D Street

Michael Tremblay <mtremblay@portlandmaine.gov>
To: Helen Donaldson <hcd@portlandmaine.gov>
Cc: Thomas Errico <thomas.errico@tylin.com>, Bruce Hyman <bhyman@portlandmaine.gov>

Tue, Feb 19, 2019 at 3:41 PM

ST. JOHN STREET & "D" STREET INTERSECTION
SCALE: 1"=10'

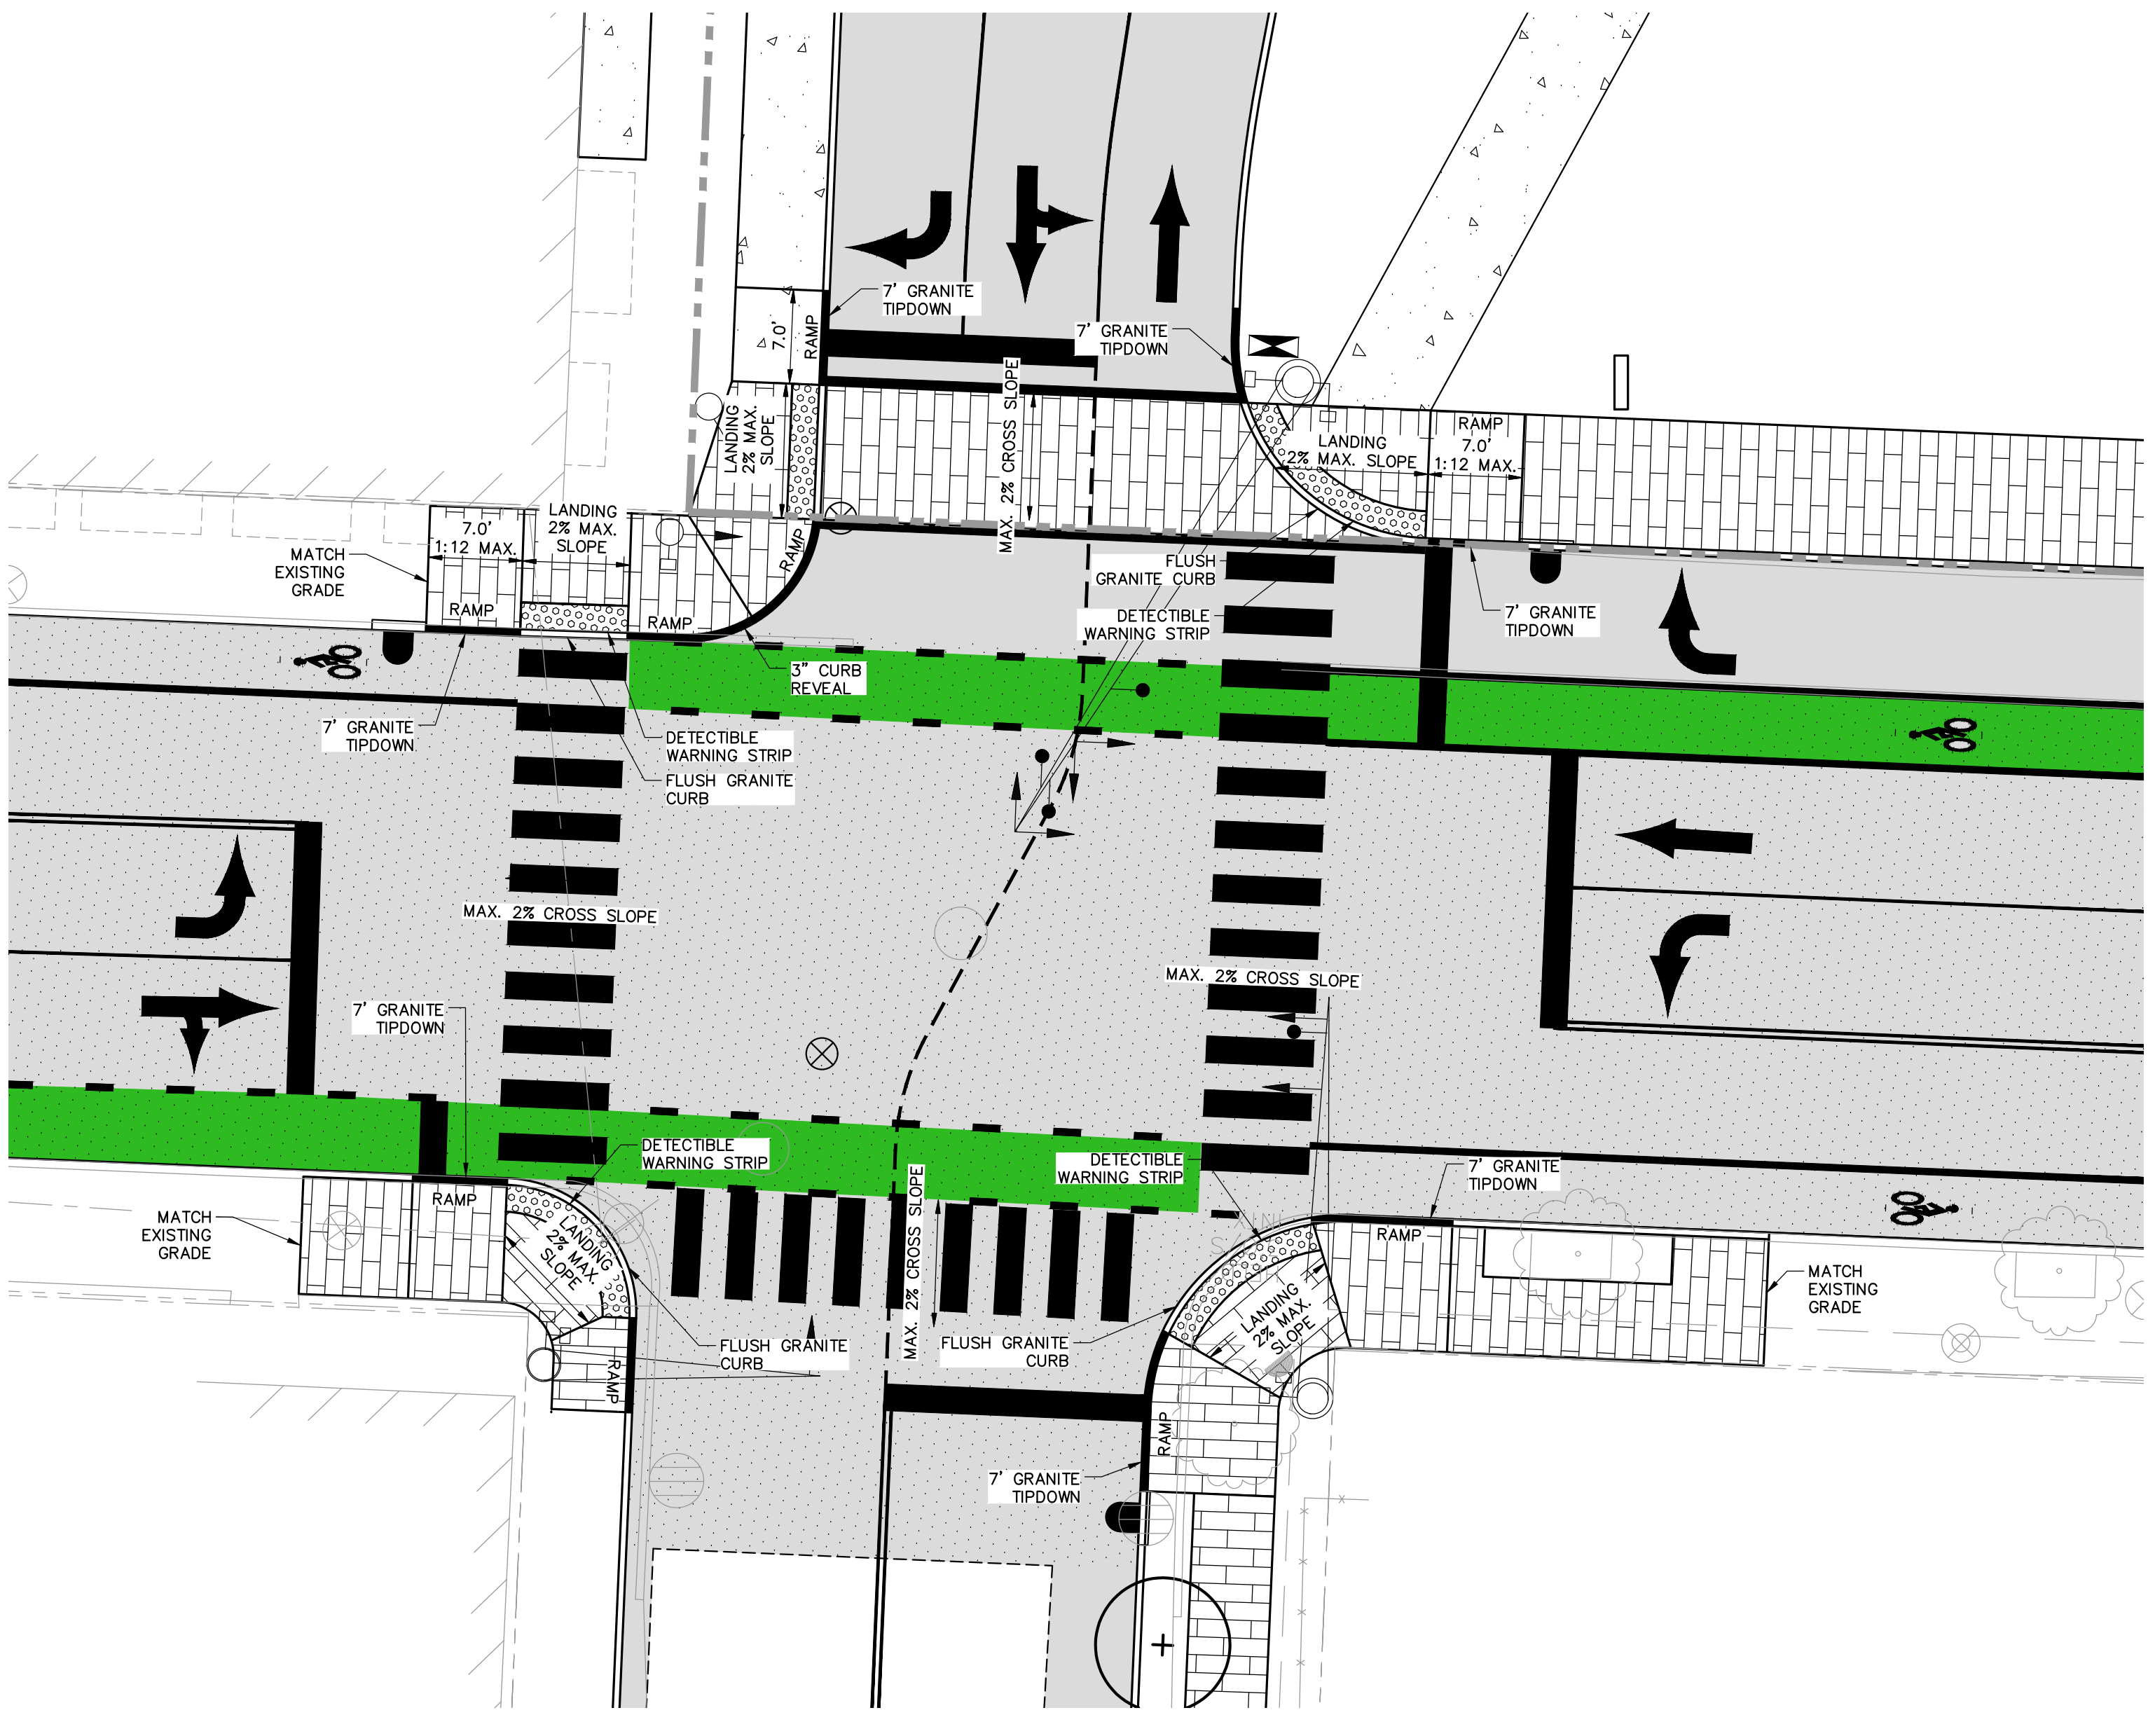
We are happy to see the new separated ramps in place of the apex (diagonal) ramps. However, in the ramps on the northeast and southeast corners of the intersection, there appear to be ramp sections that are not perpendicular to the path of travel (i.e. apron ramps), so that someone who is ramping up or down would be doing so with an undesirable cross-slope. I realize that these may have been the only way to get separated ramps in given our requirements for 7" curb reveal; however, I believe it may be possible construct perpendicular ramps if the curb reveal was reduced to 6" (or 5" minimum) in the vicinity of the ramps. If the applicant could assess whether perpendicular ramps could be installed given a reduced curb reveal, that would be preferred over the current layout.

Similar changes could be made to the southwest corner of the intersection, but these are less necessary because this corner does not feature slanted ramps.

These changes to ramp design may reduce the footprint of the ramp and make it easier to place signal equipment.
